**RE:** Barelas Park Improvements

**Grading & Drainage Plan**

**Hydrology File: K14D047**

Re: Barelas Park Improvements G&D Comments

| 615792                  | K-13 & K-14            | C-103       |             |

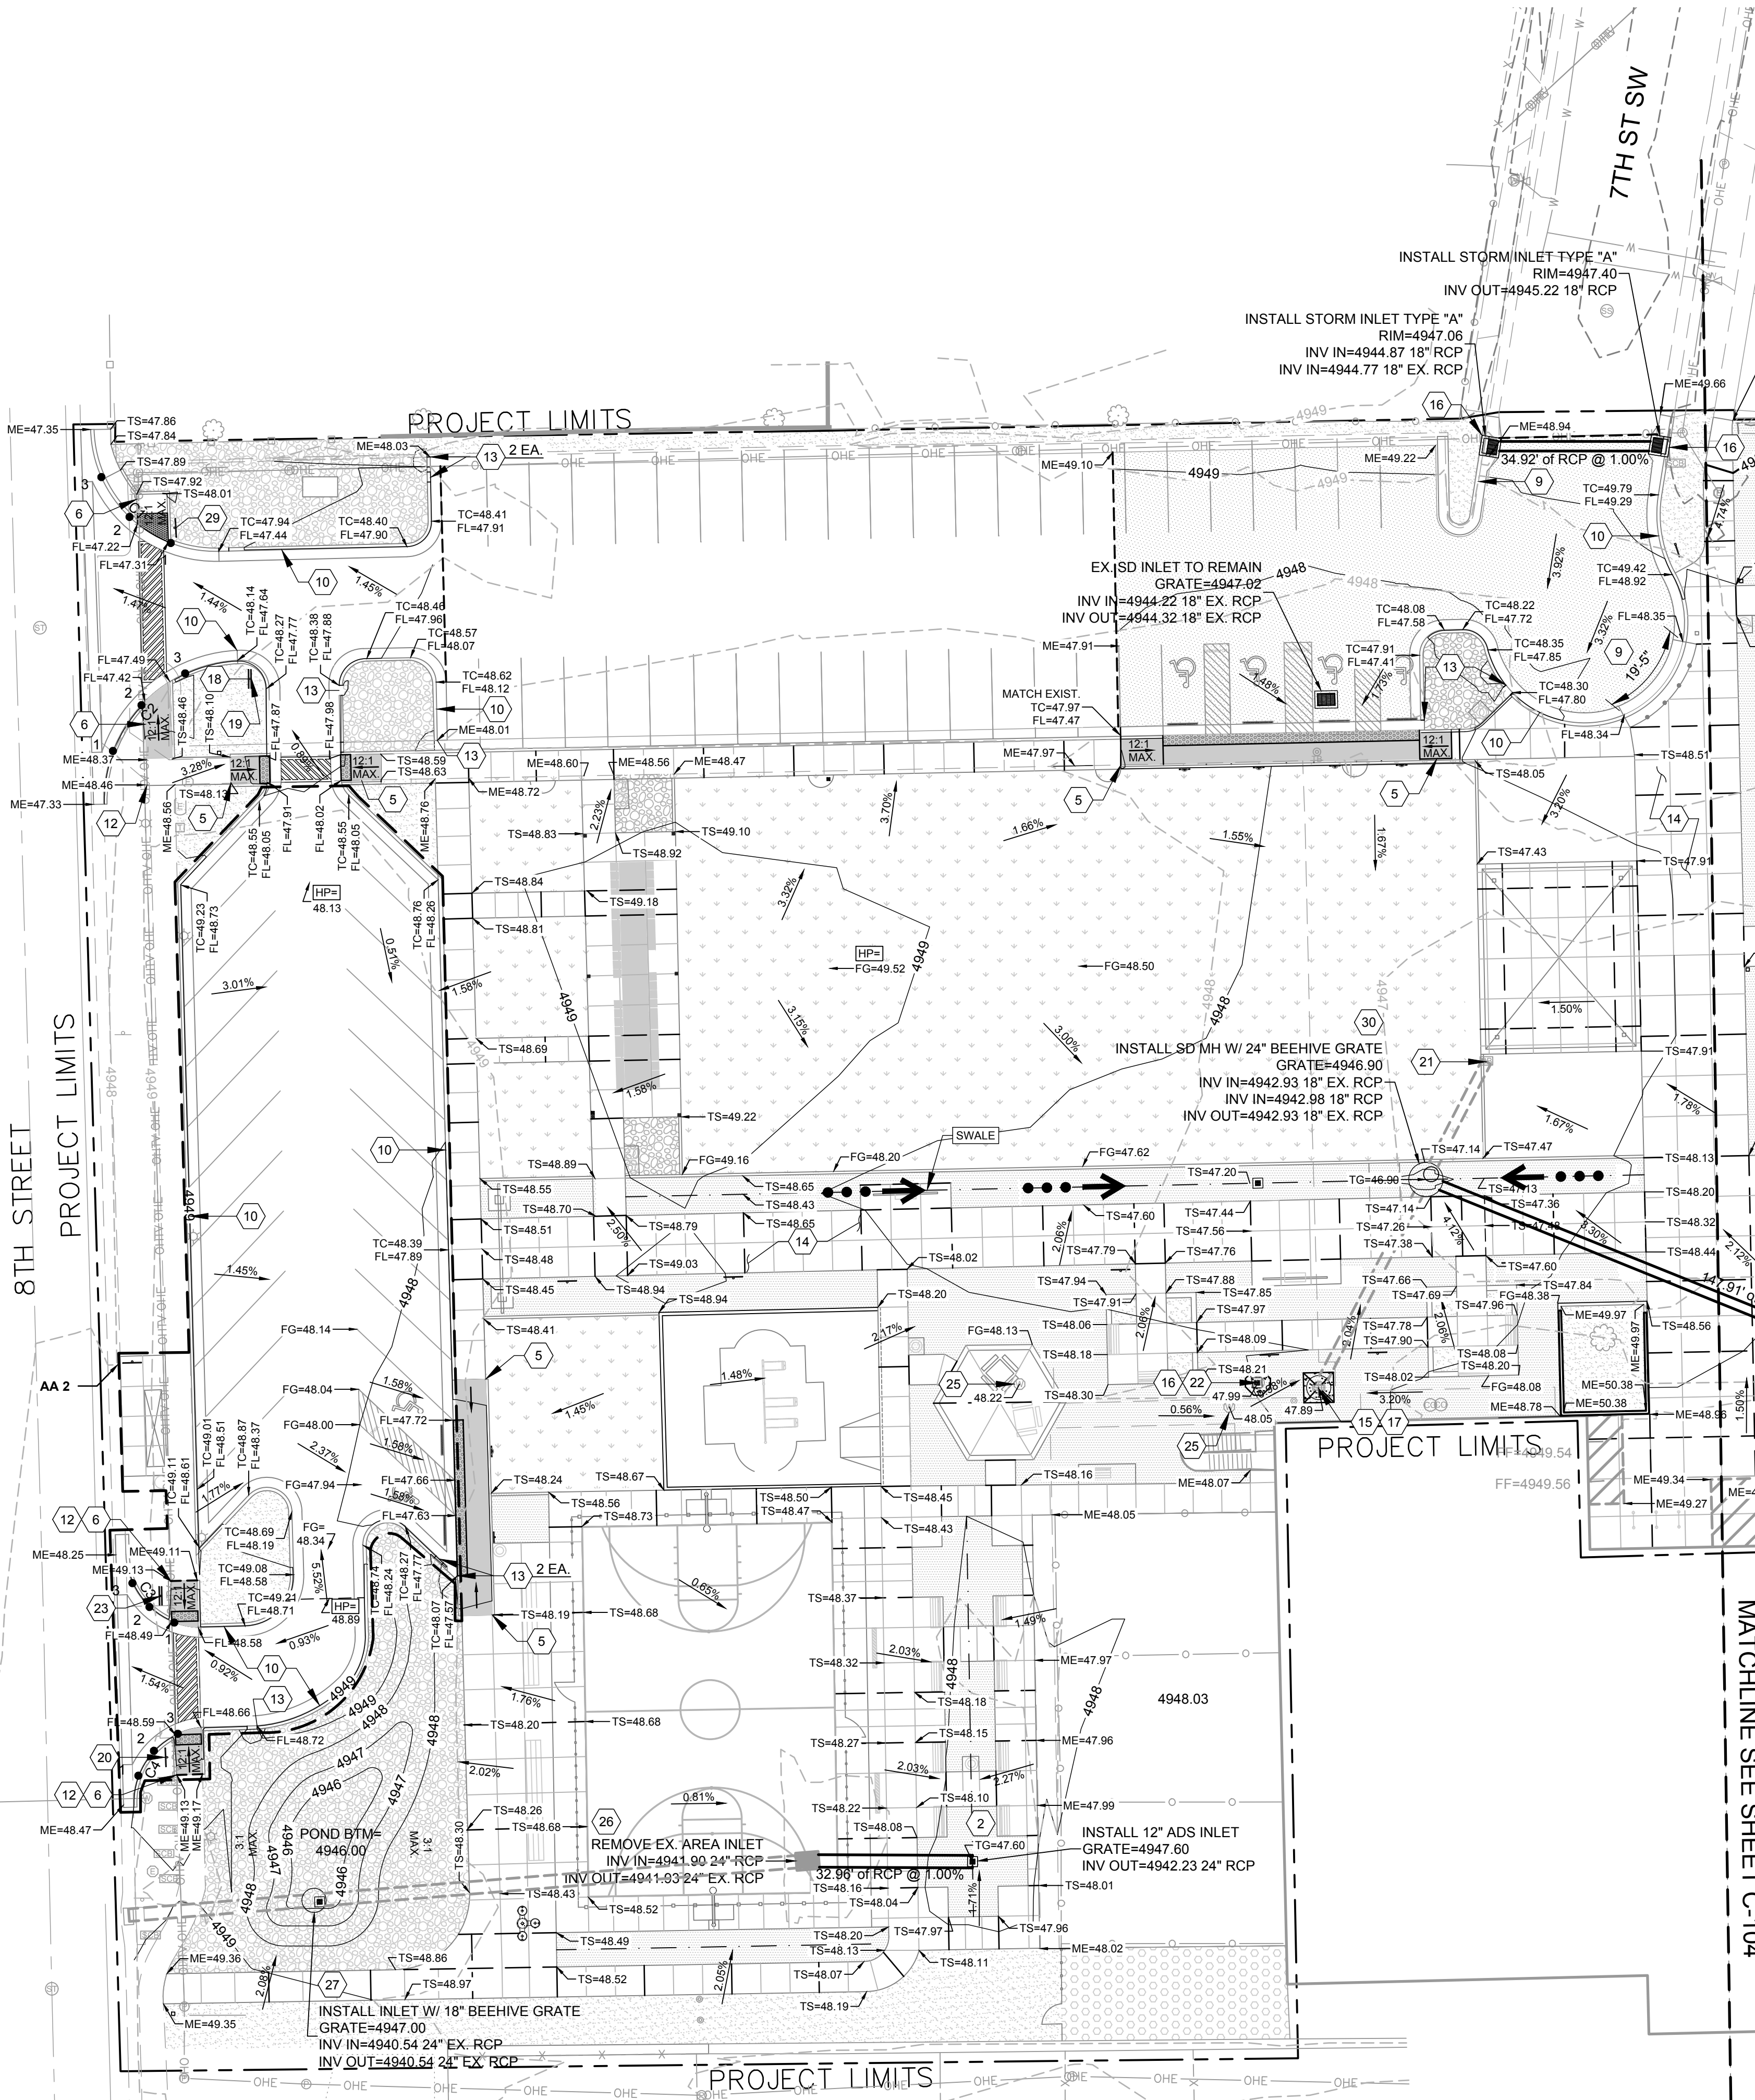
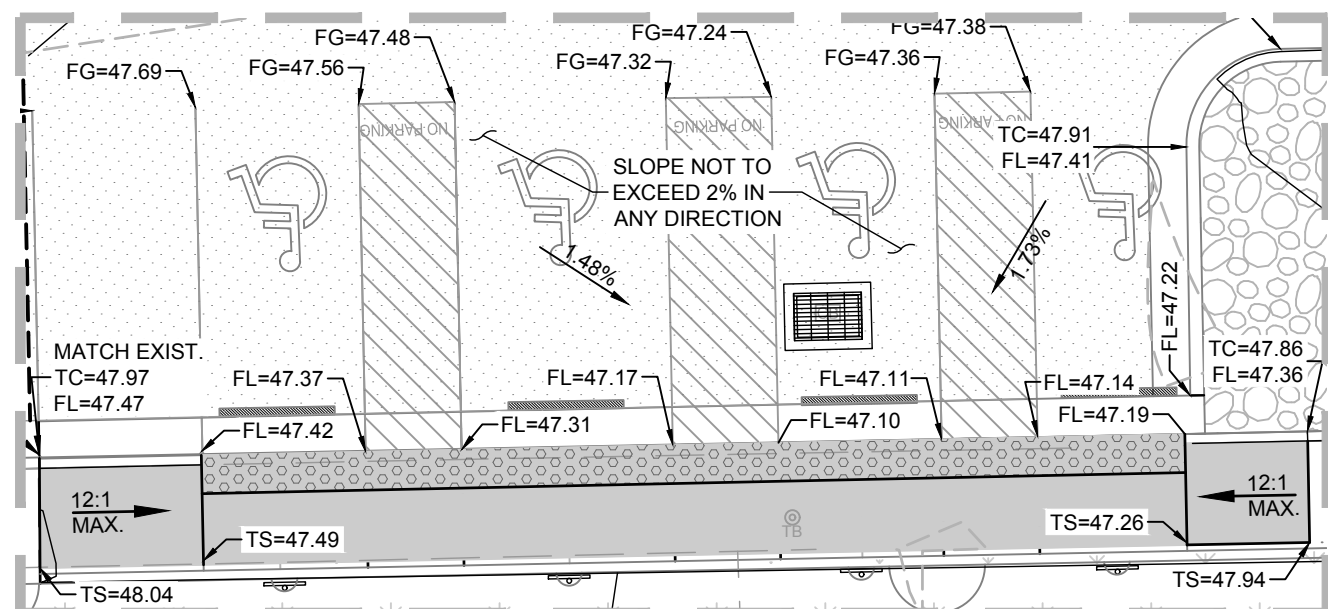
What could be helpful is showing the existing storm sewer. This could be labeled either "field verified" or "not field verified".

Pond 1 has two power poles in the middle of it. Is this pond actually a viable pond? Would the excavation of it cause the two power poles to be compromised? Please verify if this pond can be used. Also, where is the pond outfall? Typically, this is a sidewalk culvert at the elevation of the Stormwater Quality water surface elevation but there is no place to put a sidewalk culvert.

Pond 2's outfall will be the Beehive Grate. The grate elevation should be the same as the elevation of the Stormwater Quality water surface elevation for the pond.

Please add this note for all Stormwater Quality Ponds. "Pond side slopes need to be stabilized with Native Grass Seed with Aggregate Mulch or equal (Must satisfy the "Final Stabilization criteria" CGP 2.2.14.b.)".

See plan for adjustments.

This is a landscape depression. There is a curb cut that allows for flow to exit the depression area on the south side.

See plan for adjustments.

See plan for adjustments.
